reference number TR010030 and unreferenced Commons Act s38 dated 13 December 2019.

1. My name is Bob Milton. I am a member of the Institute of Public Rights of Way and Access Management [IPROW] and an independent consultant on Rights of Way and Common Land. I am making this representation to formally object to the process and detail relating to equestrian access to rights of way, common land and public open space on behalf of the British Horse Society [BHS].

On behalf of the British Horse Society

### A.3 Proposed Public Access and Right of Way Network

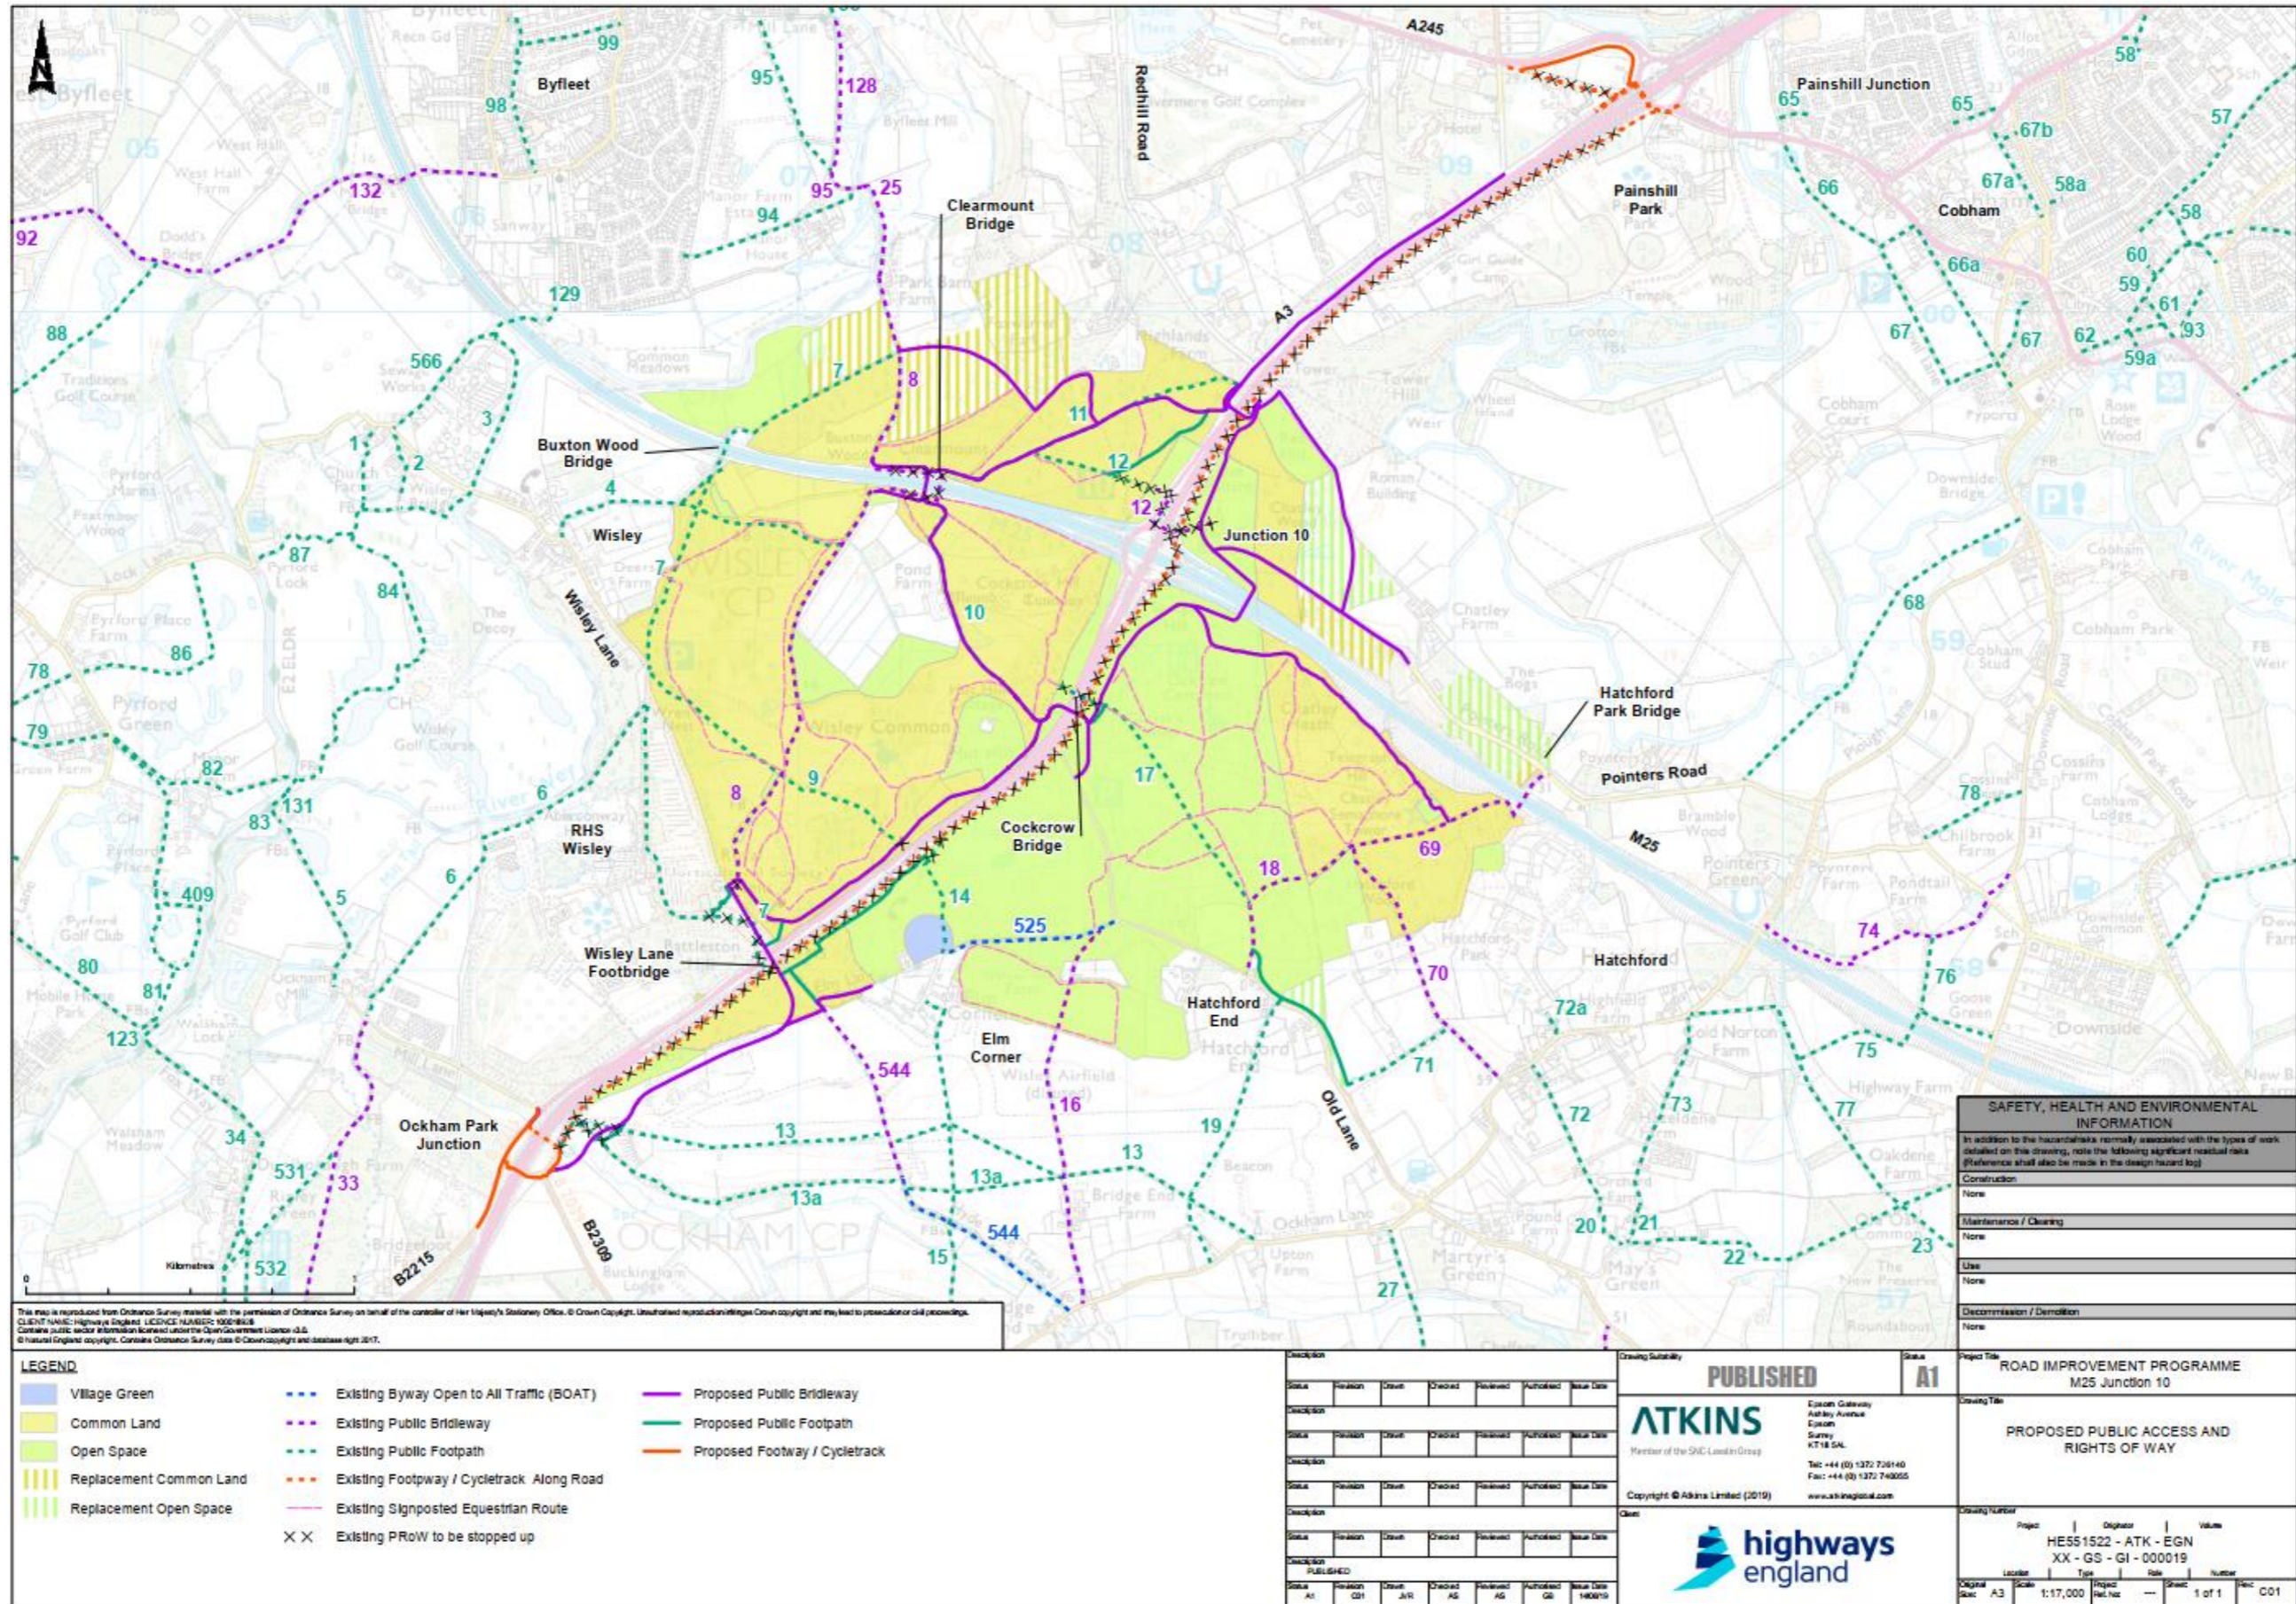
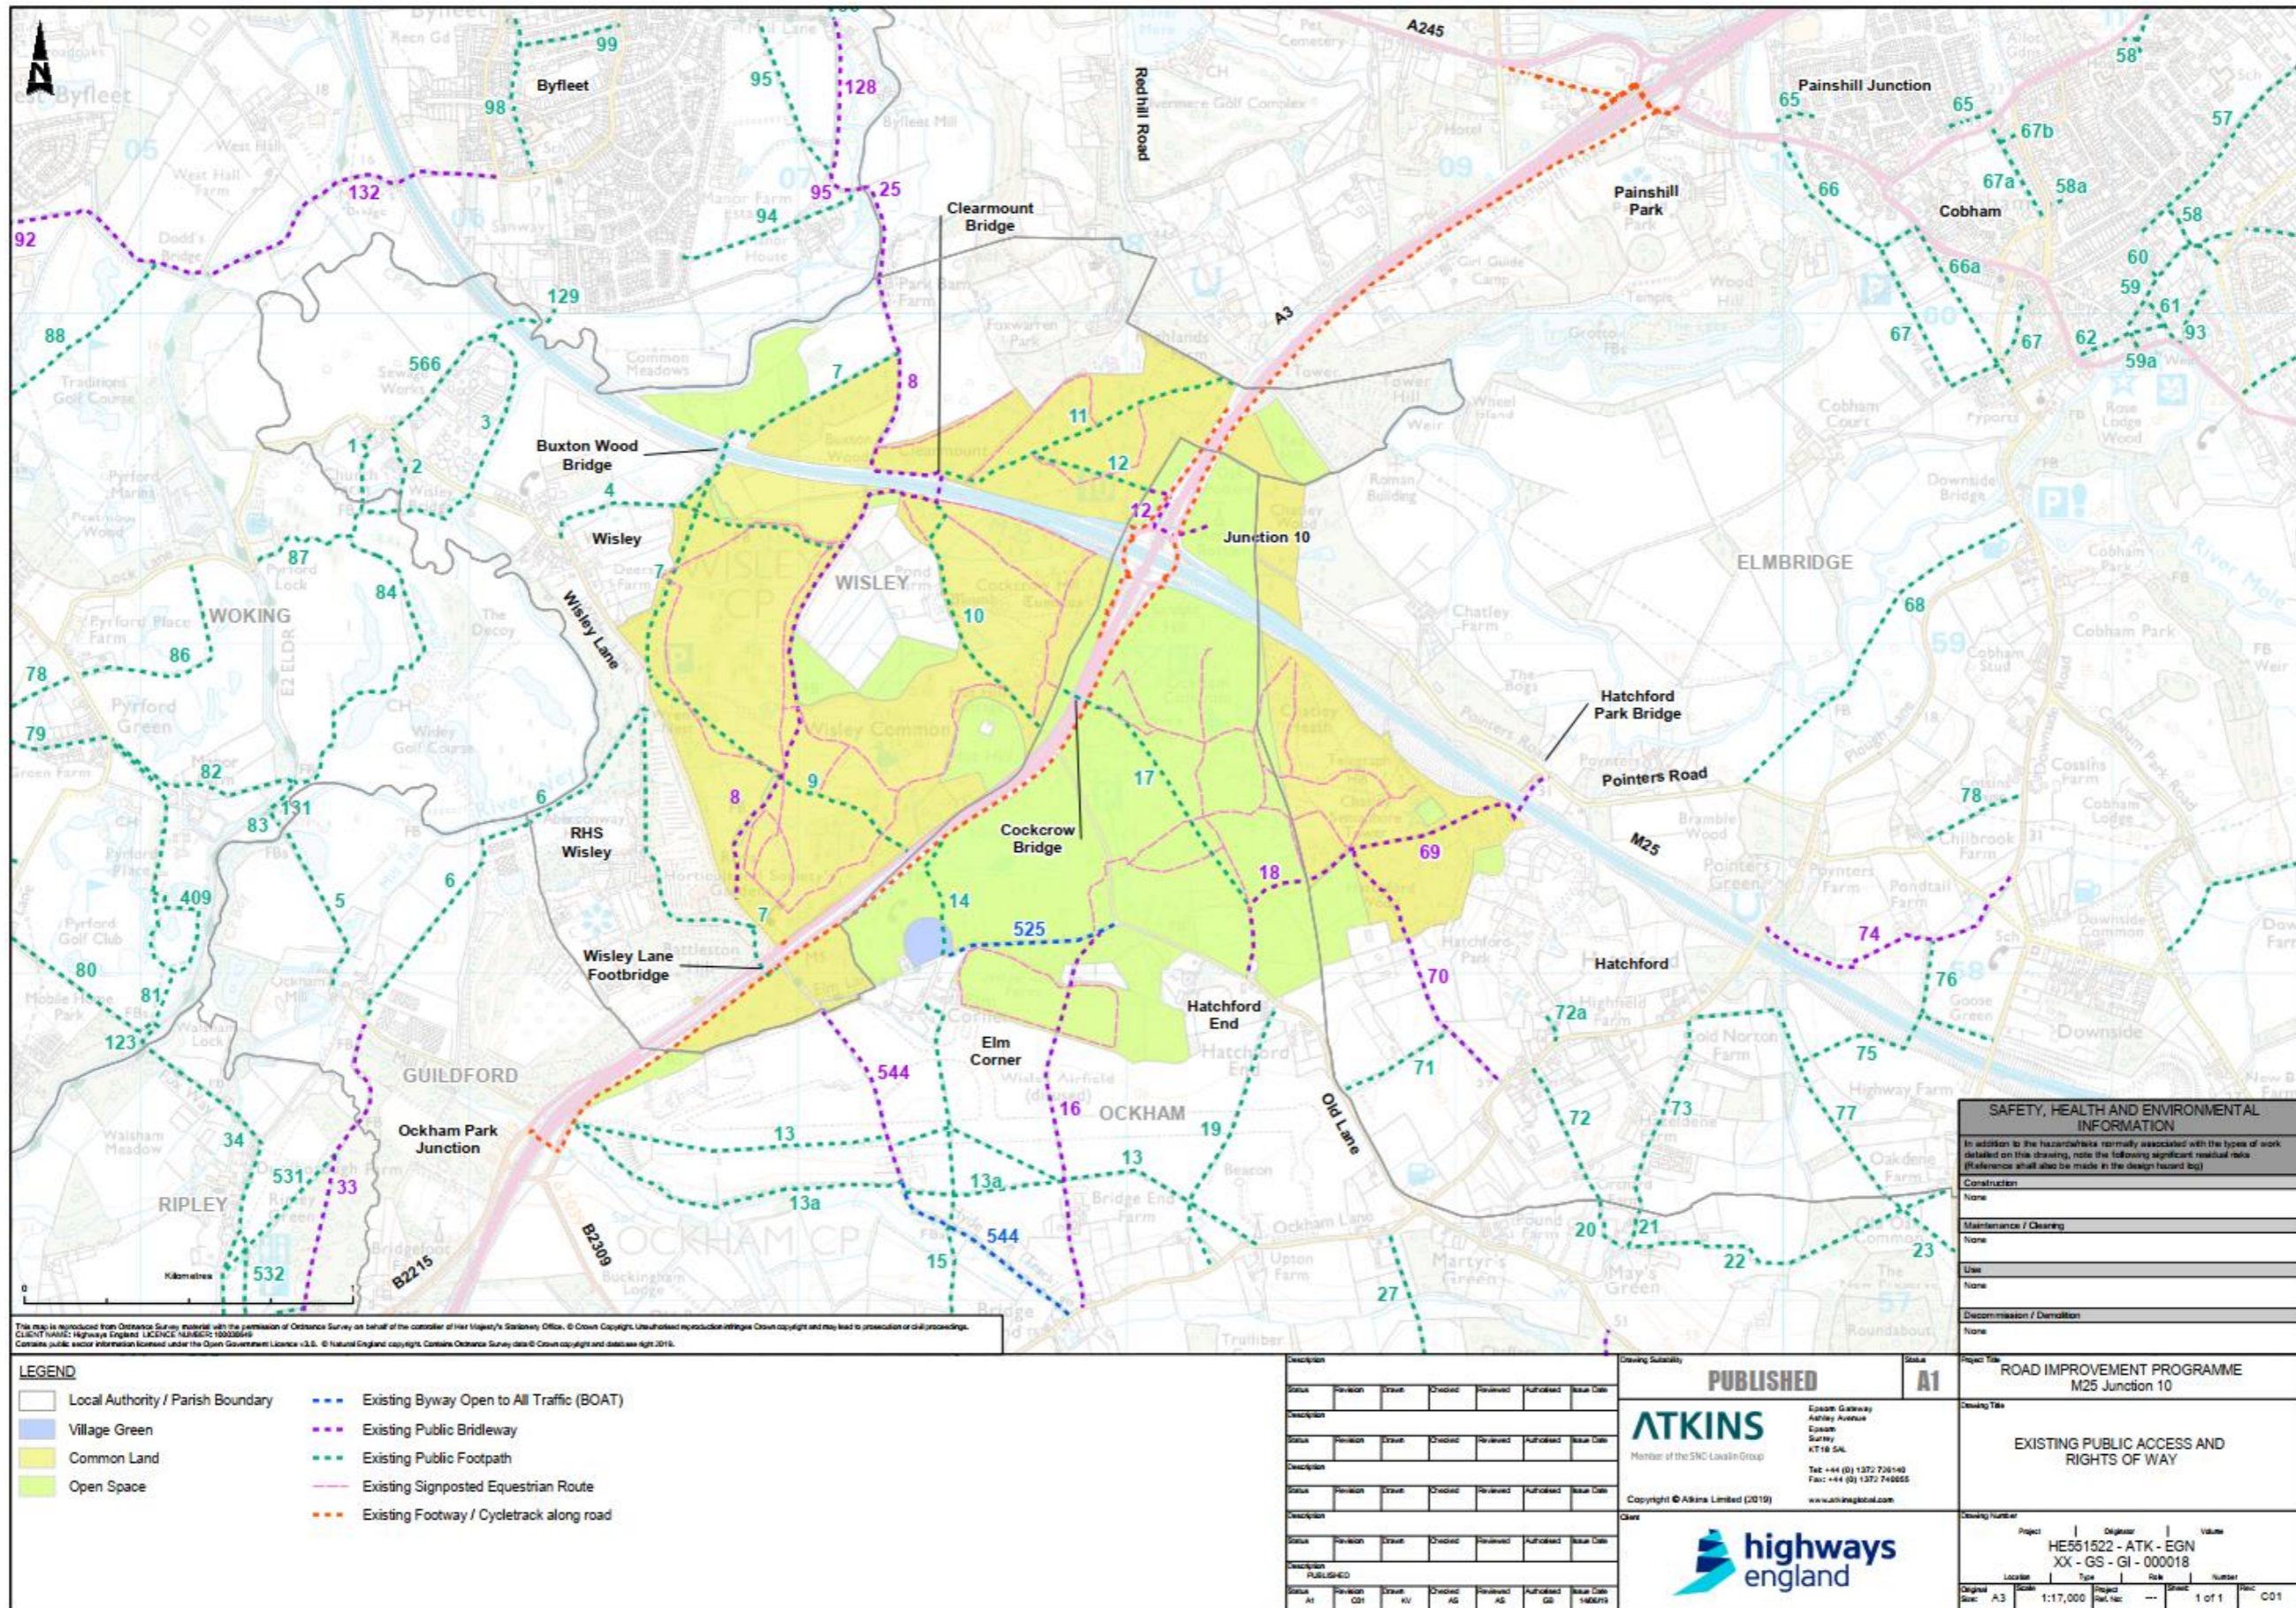
4. The changes are too great to list in detail but suffice it to say that what was to be a north south non-motorised user multi use path as part of the carriageway alongside Warren Mere has been removed and replaced by a convoluted bridleway on the opposite side of the A3 over the common without exchange land or access north south for carriage driving. This brings with it an added burden on the ratepayers of Surrey as these bridleways and footpaths will be maintainable at public expense.

5. The siting of the revised bridleway network into the common land grazing enclosures with the attendant conflict between grazing animals and lawful users has not been considered. This site has already seen conflict between lawful users – equestrians [including an unreported RIDDOR hospitalisation] and pedestrians with dogs - and the grazing regime imposed by Natural England and funded by the Rural Payments Agency.

10. The first is the continuation of no equestrian access where FP7 crosses the M25 over the RHS accommodation bridge and connects all the exchange land for this scheme, the RHS and past schemes. The special land documents TRO10030/APP/2.5(1) 13 March 2020 do not consider the interplay across the different designations forming the overall public recreation land. At the same time the scheme leaves many small and in terms of lawful public recreation and access, inaccessible areas. These should be added to the whole of the exchange land provision instead of being isolated. The latest proposals in 9.74 3<sup>rd</sup> March 2020 need some detailed discussion in relation to public rights of access and the interplay with the rights of way network as required by GG142 WCHAR and the HE Accessibility Strategy. Any overall reduction of public access common land and open space recreation land is considered unacceptable especially as this seems to have been done without any detailed consultation and discussion. The requirements relating to Quantity and Quality first dealt with in 1975 with the rerouting of the A3 across Esher Common seem to have been forgotten by both Highways England and SCC. My time was offered on behalf of the BHS to the promoter on January 10<sup>th</sup> 2020 to assist in the consolidation of the rights of way network and exchange land but was not taken up.

11. The second is the link between BW12 and the rest of the network which at the moment goes from BW to FP on the registered common at the parish boundary via two recently constructed Pegasus crossings of the north side slip roads.

12. Thirdly there is only provision for cycle *access on demand* crossing lights at some bridleway junctions with the road network and no equestrian facilities [Pegasus]. This is a serious omission by the promoter and completely against the requirements of GG142 WCHAR. Again, had there been proper consultation at any time this and other anomalies could and should have been dealt with.
